Re: Marysville Corporate Center – *Technical Review 3*
PA 22004

After review of the revised application materials, the Planning Division has the following comments:

RE: Marysville Corporate Center, File# PA22-004
Binding Site Plan
15908 47th Ave., Multiple Parcels

SHEET TITLE:
COVER SHEET

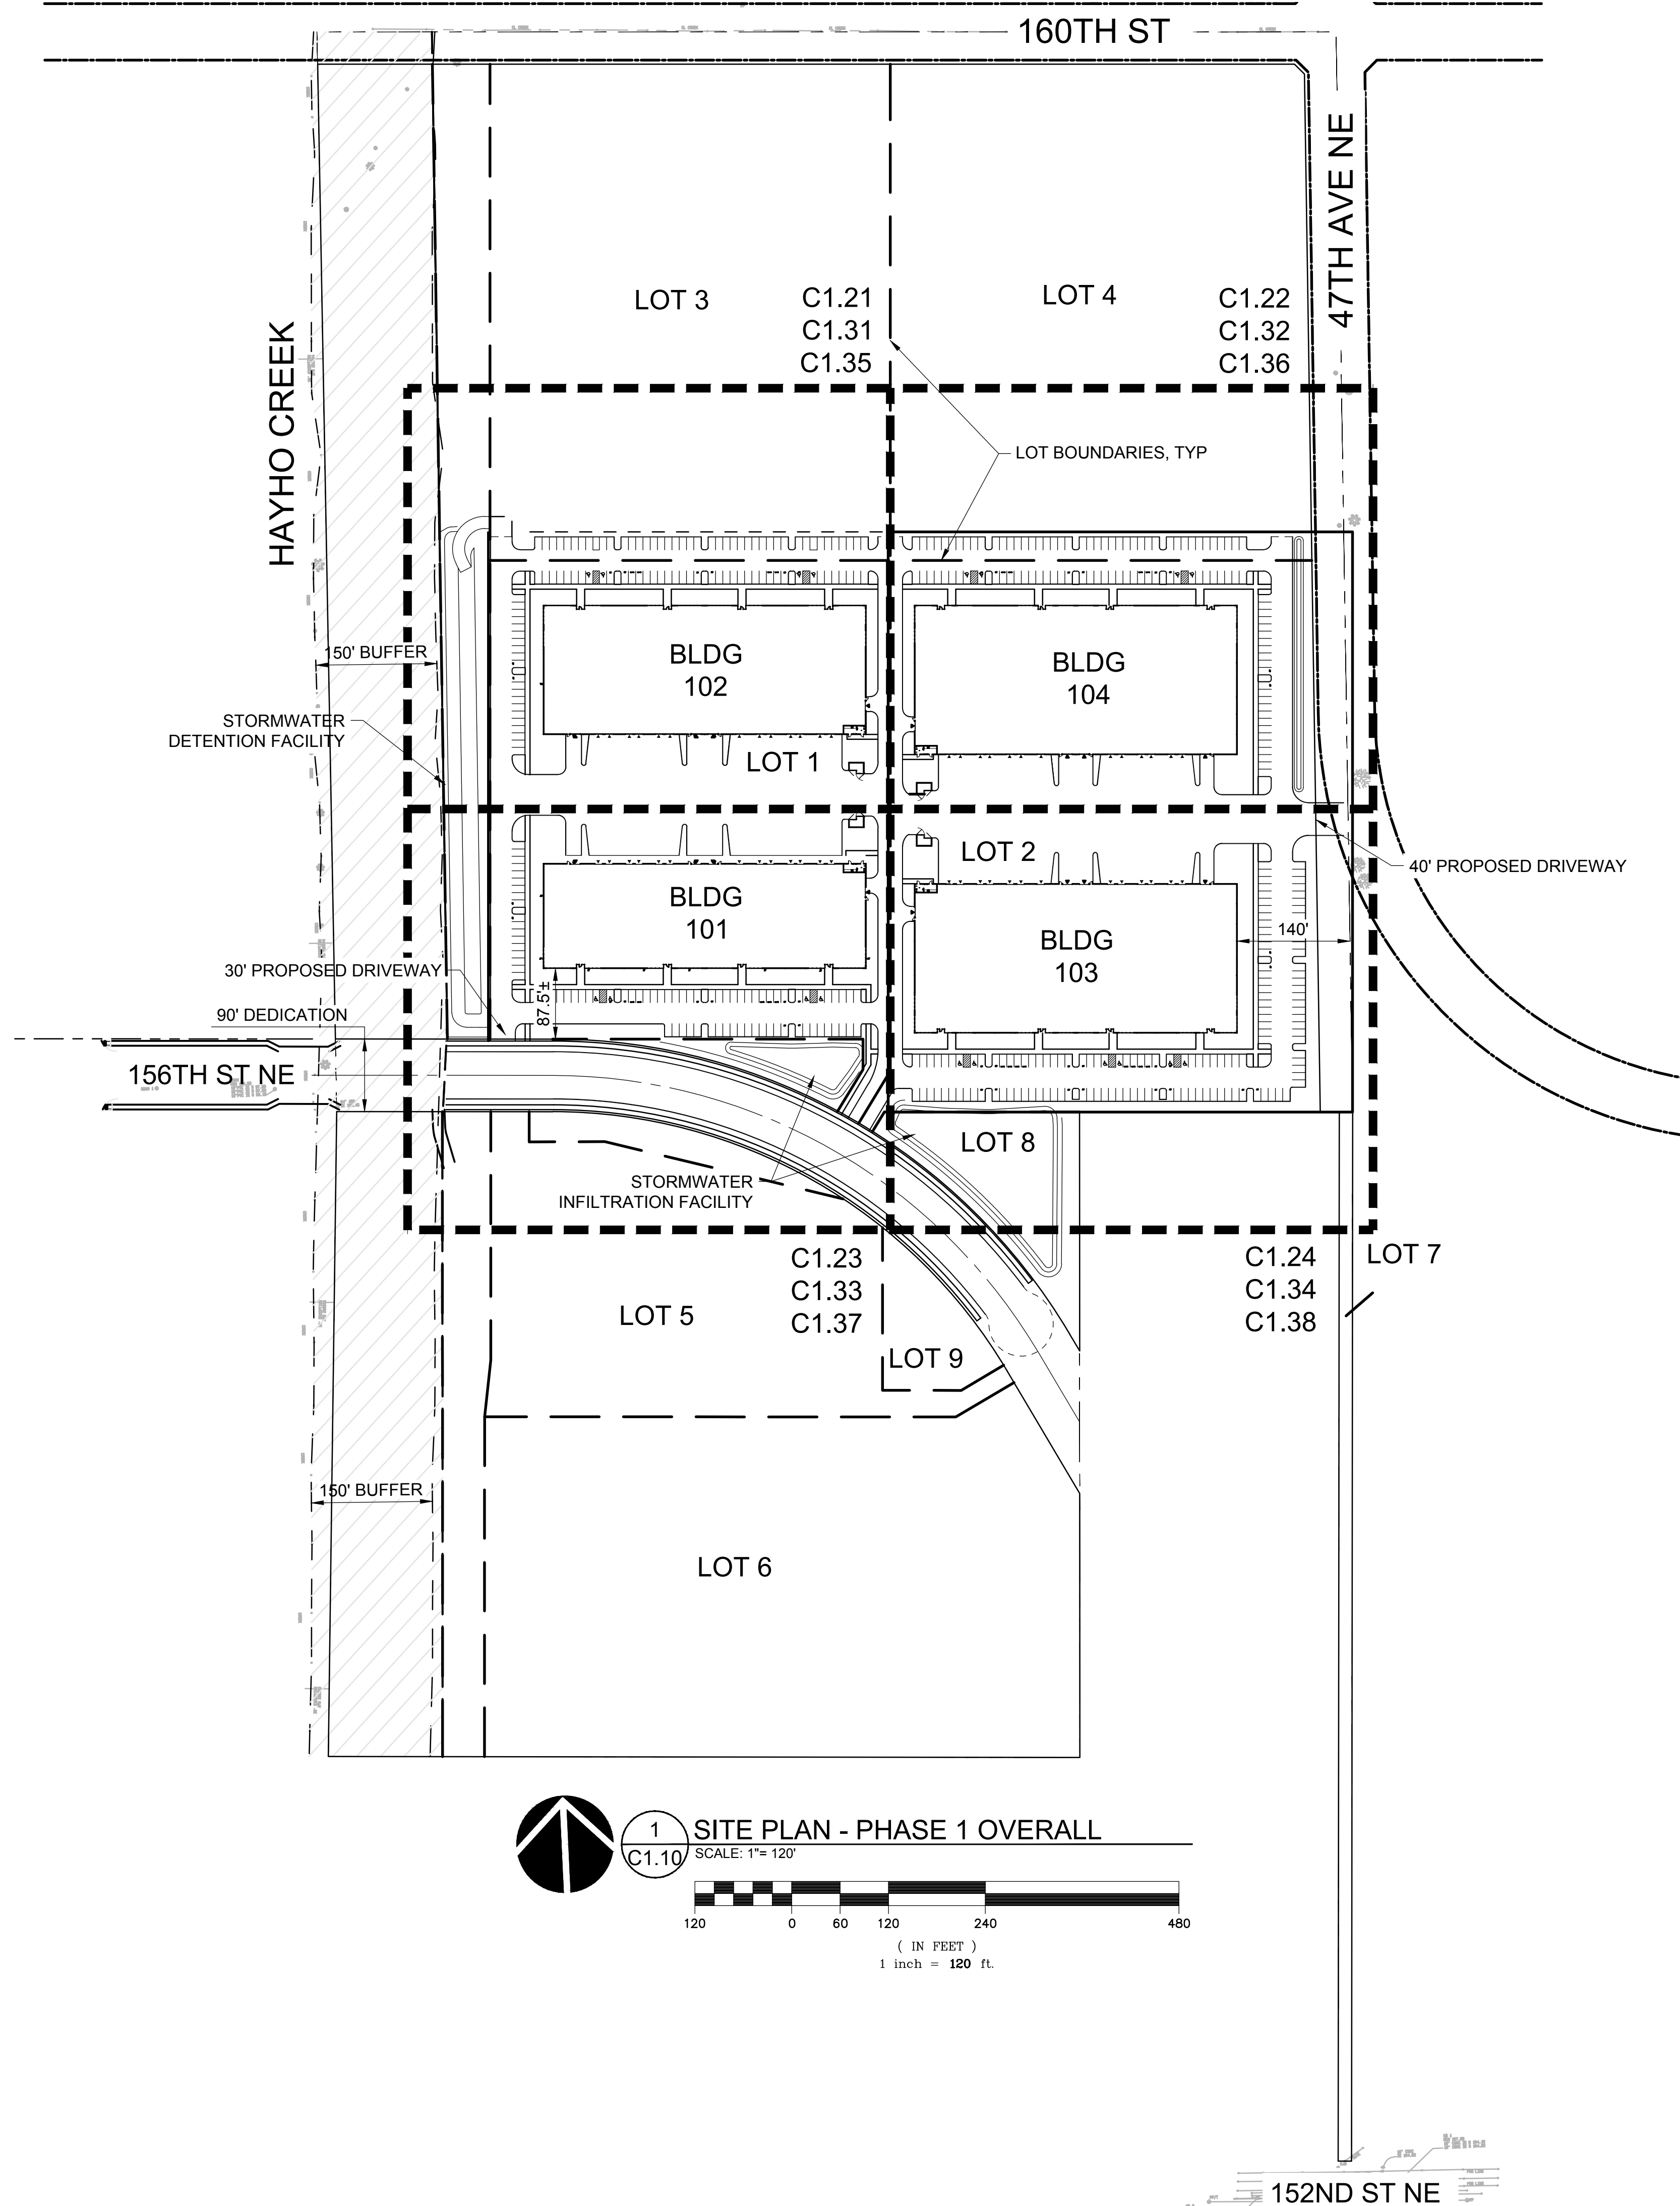
- d. A minimum 15' L3 landscape buffer shall be provided along 156th Street NE, 160th Street NE and 47th Avenue NE.
 - e. In review of the "ZONING COMPLIANCE" section on Sheet L0.01 it does not appear the proposed landscaping complies with the L4 Parking Lot Landscaping provisions. 10% of the required parking areas shall be landscaped with L4 landscaping.

**SHEET 1 OF 13**

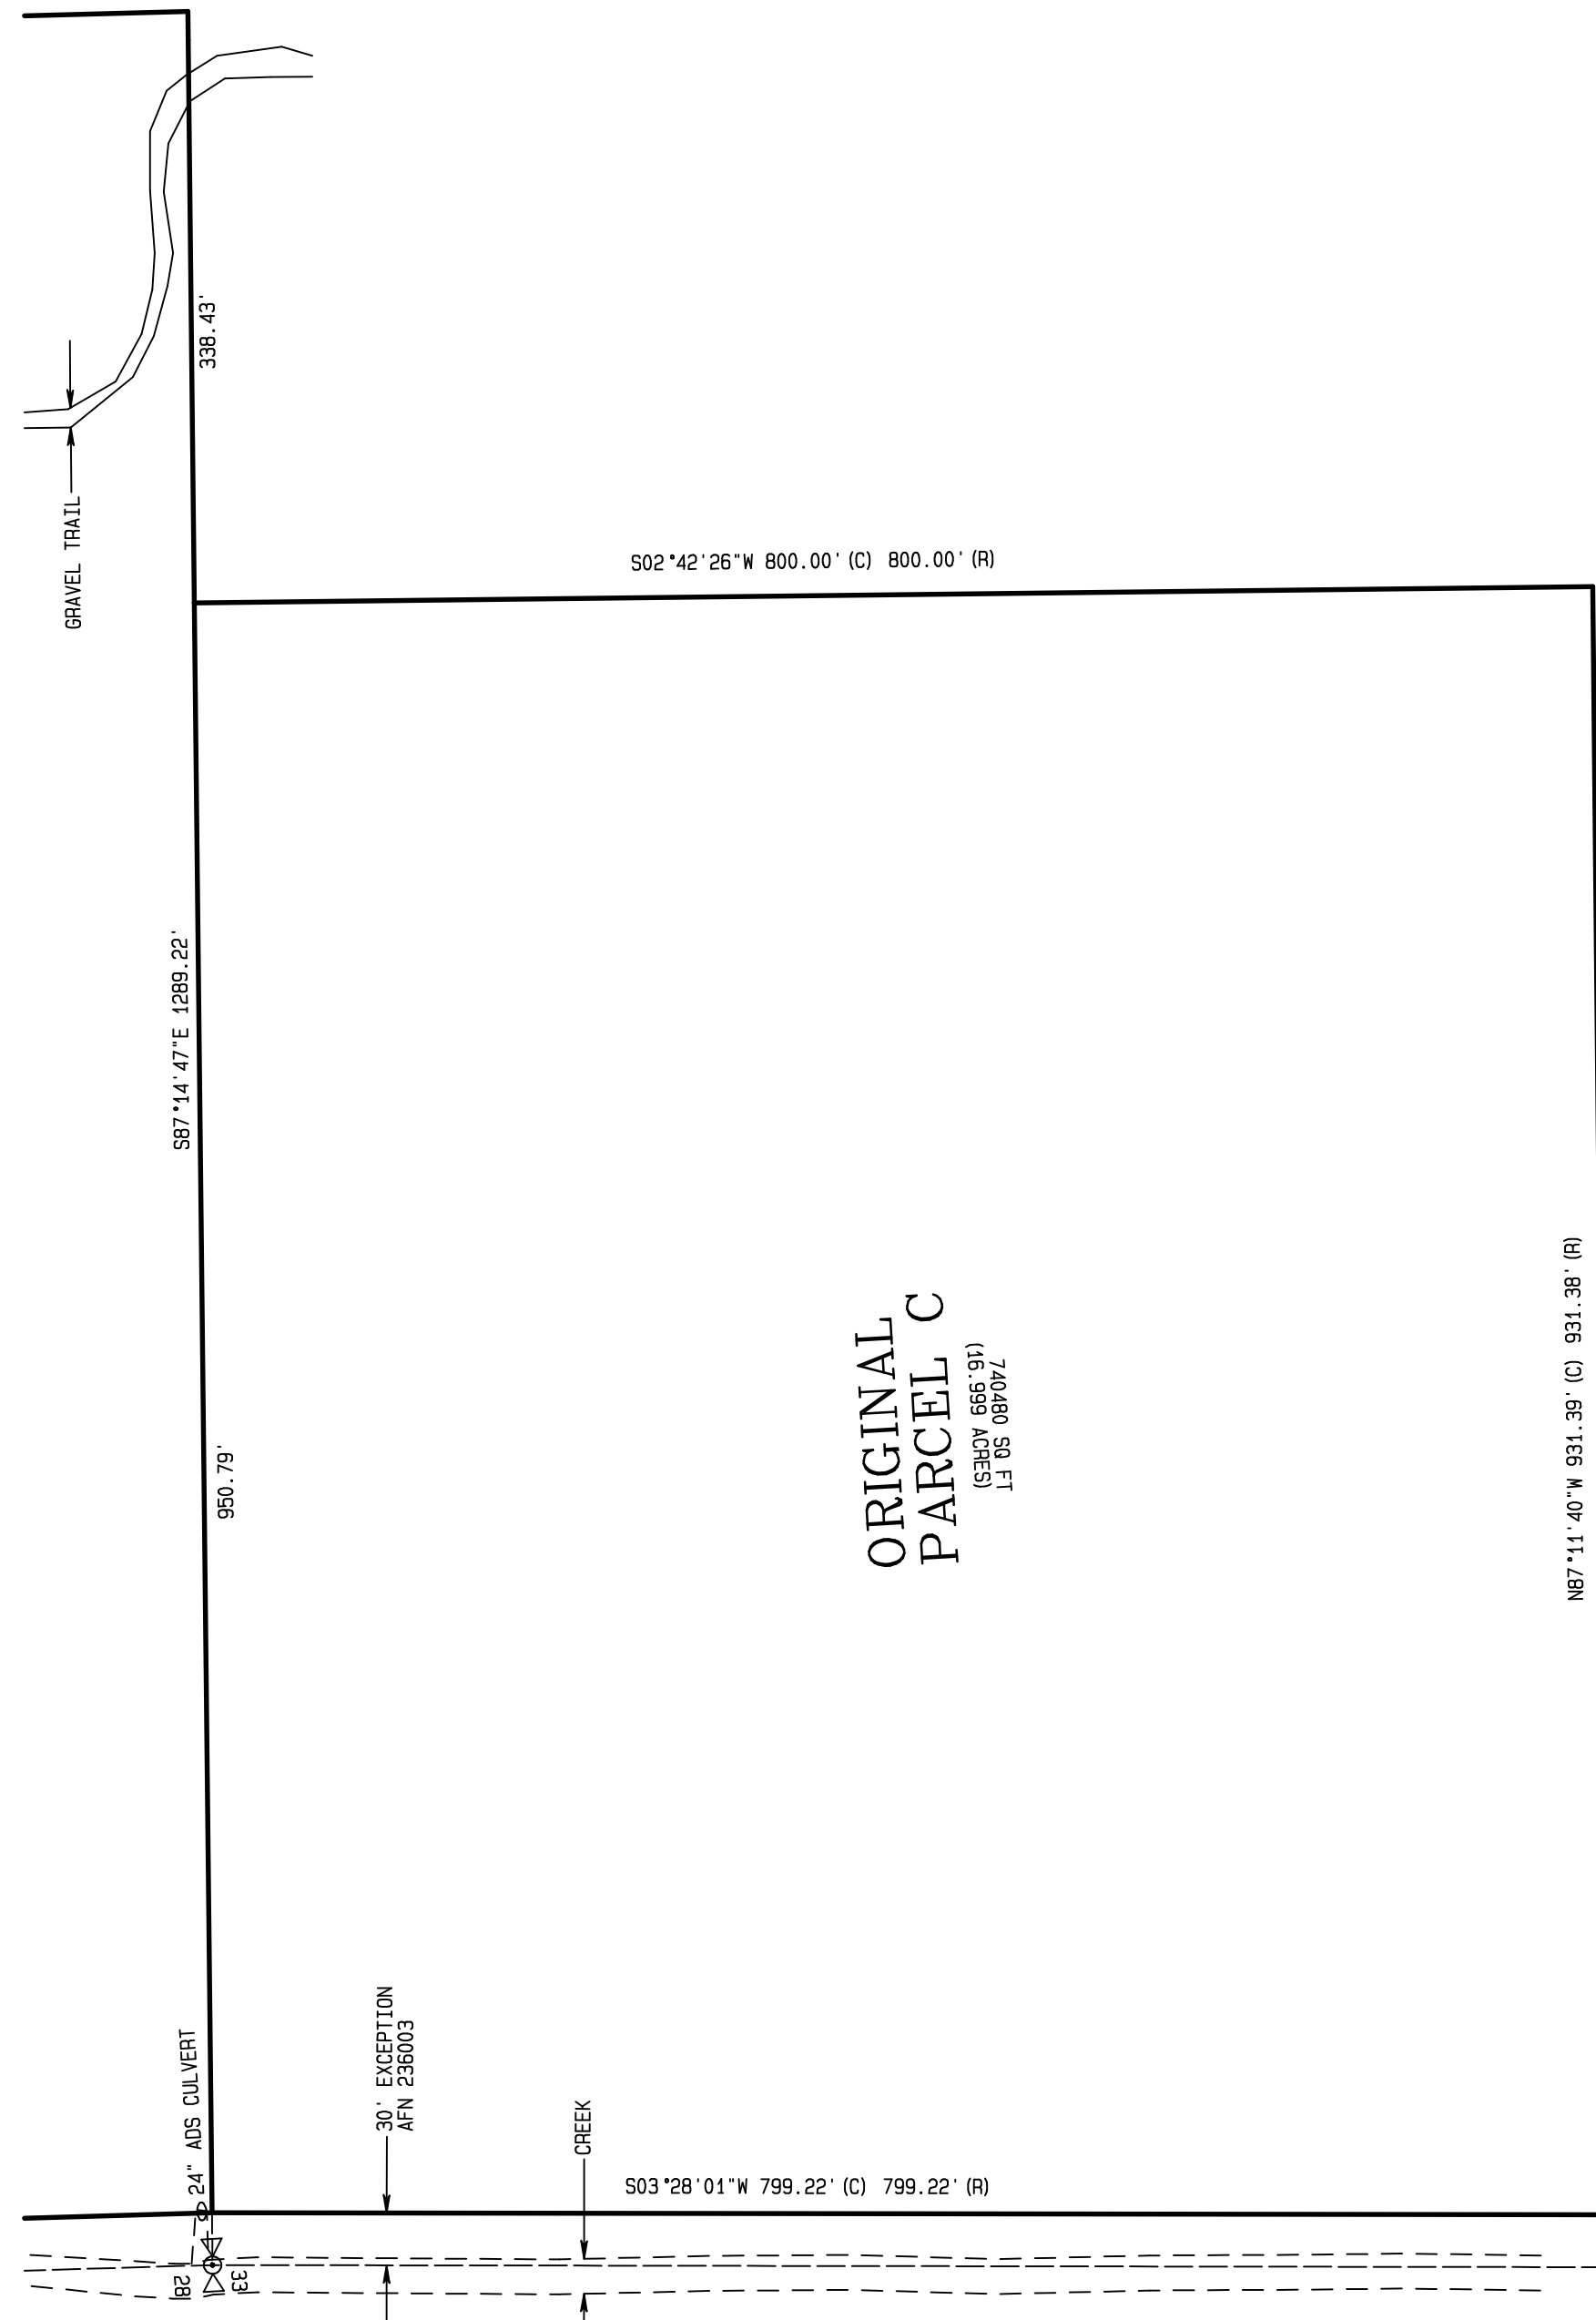
1. Amend ***all applicable sheets***, as follows (see attached redlines):
 - a. The proposed Lot Numbers go from Lots 1 – 6, skip Lot 7, and include Lots 8 & 9. Lot numbers will need to be amended to be consecutive.
 - b. Amend Lot numbers so they are successive from top to bottom.
 - c. Are Lots 8 & 9 storm facilities? If so, they will need to be referenced as Tracts and not Lots.
 - d. Amend Tracts B-1 & B-2 to have their own individual letter and omit the number.
 - e. Tracts A & D are Natural Growth Protection Areas Tracts (NGPA) and will need to be labeled, as such.
 - f. Provide ADA parking calculations and locations.
